A57 LINK ROADS

TR010034

CPRE Peak District and South Yorkshire Branch

CPRE PDSY DEADLINE 4 SUBMISSION – RESPONSE TO ISSUE SPECIFIC HEARING 2

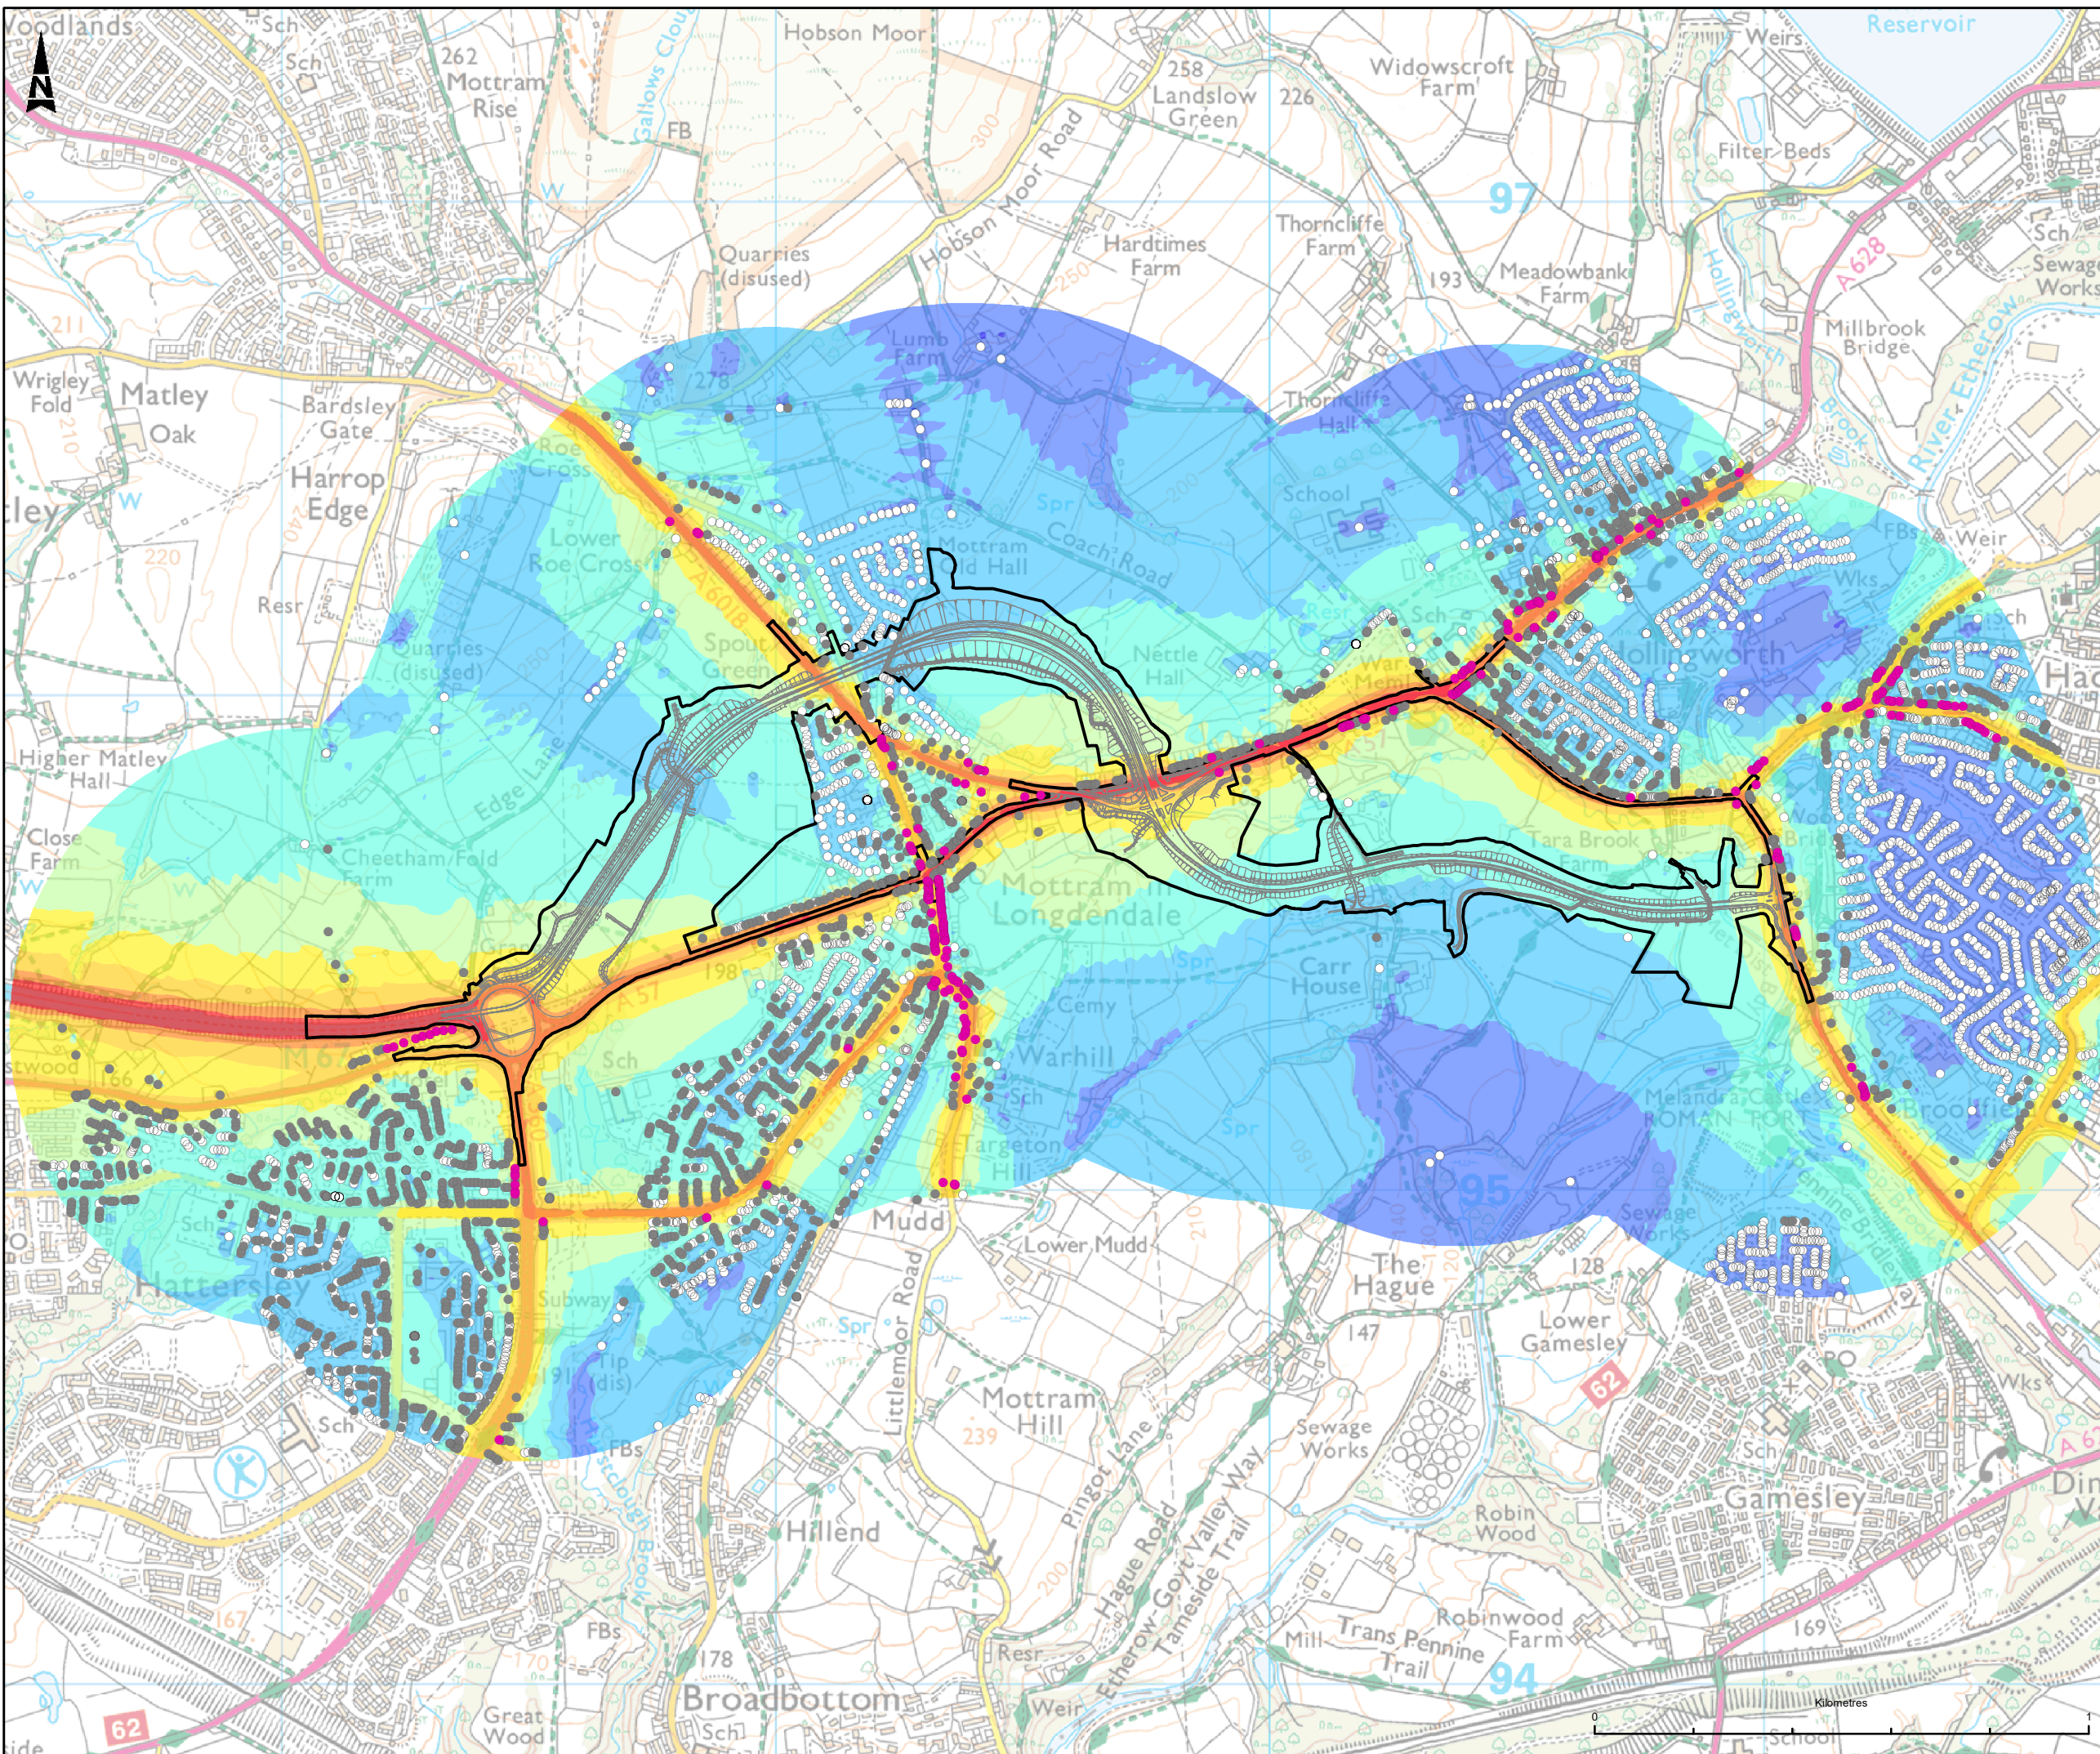
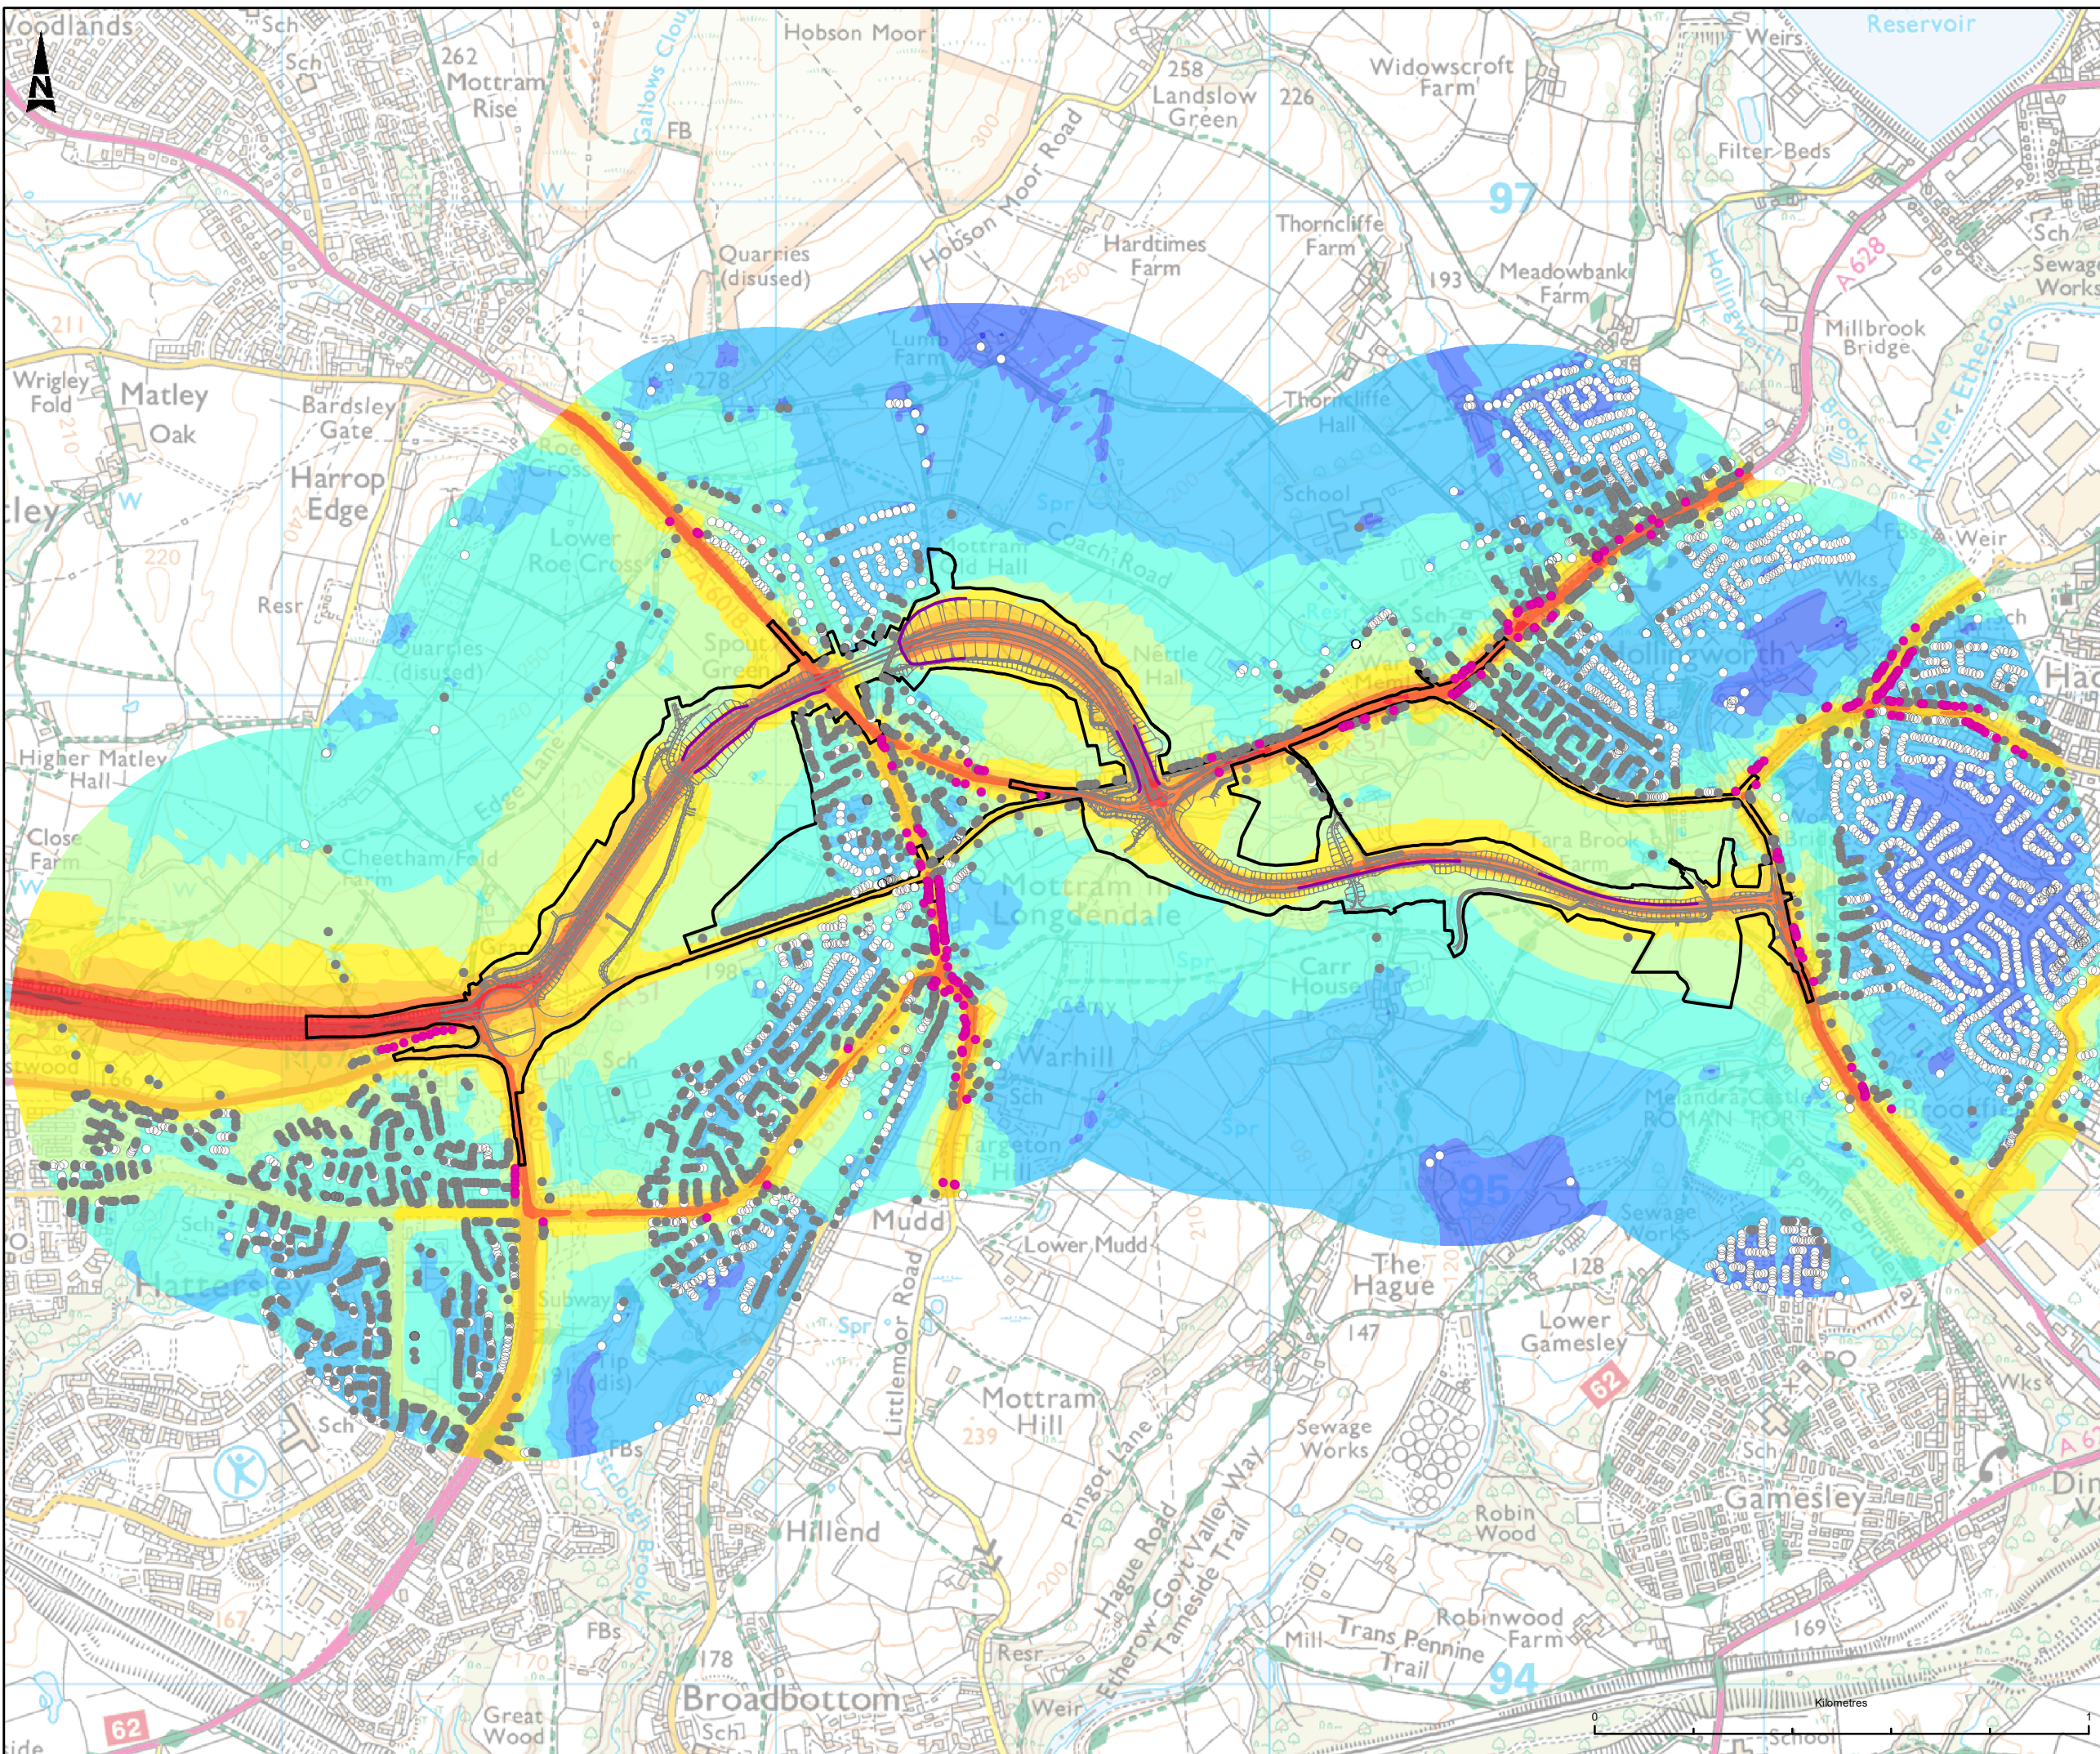
Using the single element noise to measure the impacts of the scheme on National Park's landscapes fails to capture the full effects of the increased traffic. Noise is only one element of tranquillity, which is a multi-layered quality of the countryside and part of the natural beauty of the National Park. Tranquillity is the calm experienced in places with mainly natural features and activities. CPRE's maps reflect both physical qualities and elements and the subjective experience of tranquillity – what is tranquillity, what detracts from it and what enhances it. As the tranquillity map of Derbyshire (page 14) shows the landscape around the A57 Snake Pass is one of the most tranquil in the Peak District. It is a natural landscape, wide open blanket bog and heather moorland, with birds such as curlew and golden plover but above all where silence peace and quiet can be found. The landscape around the A628 is less tranquil but the aesthetic and perceptual qualities are strong in the landscapes adjacent to both roads - solitude, inspiration and awe at the astonishing beauty, threat from the terrain or weather. The top detractor from tranquillity according to the

CPRE assessment is hearing constant noise from cars, lorries and motorbikes. Traffic was strongly verified as being something not seen in a tranquil place, and car noise as something

not heard in a tranquil place. If National Park purposes are to be met and tranquillity enhanced then traffic along both routes should be reduced, not increased.
